**Consultation Response from KC,  
Highways Development Management**

**2024/92454 Land to North and South of, Crossley Lane, Dalton, Huddersfield, HD5 0QP**

**Date Responded: 29-10-2024.**

North / M62 – Via Kirkheaton

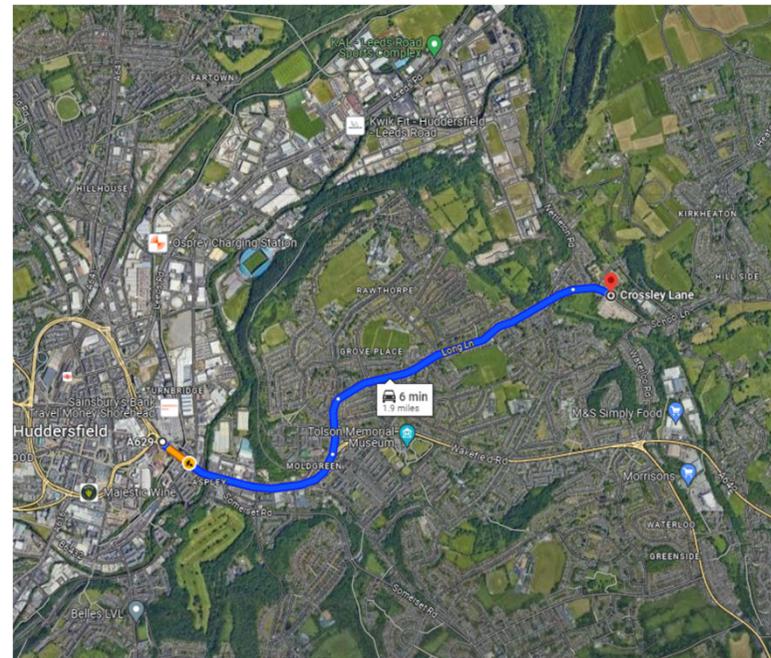
The proposed Construction Management Plan is generally acceptable, other than the route to the site via Kirkheaton should be omitted. There is a 7.5 tonne weight limit on New Road and Kirkheaton Primary School is located along the route.

This condition should **not** therefore be discharged.

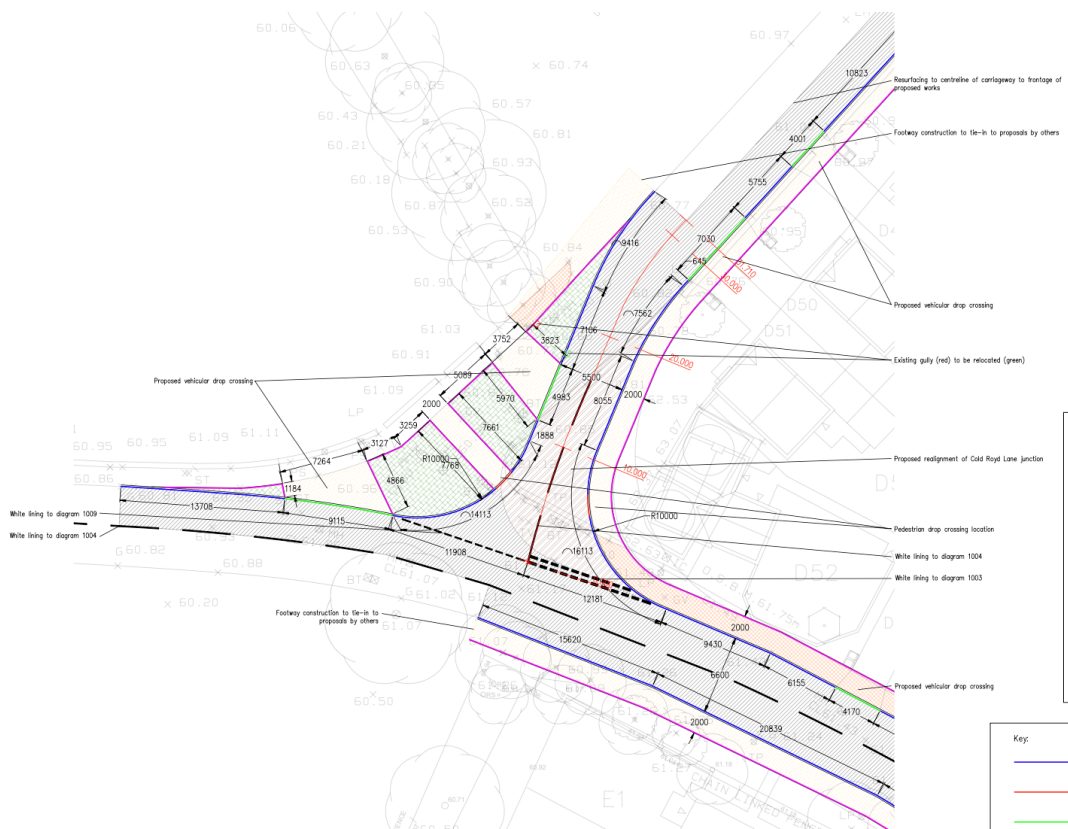
The proposals shown in Paragon Highways Technical Note would leave no footway to the southern side of Crossley Lane between the Sutton Avenue and Cold Royd Lane junctions. This would become the only length of missing footway along the whole length of the southern side of the site which can't be in the best interests of highway safety.

This condition should **not** therefore be discharged.
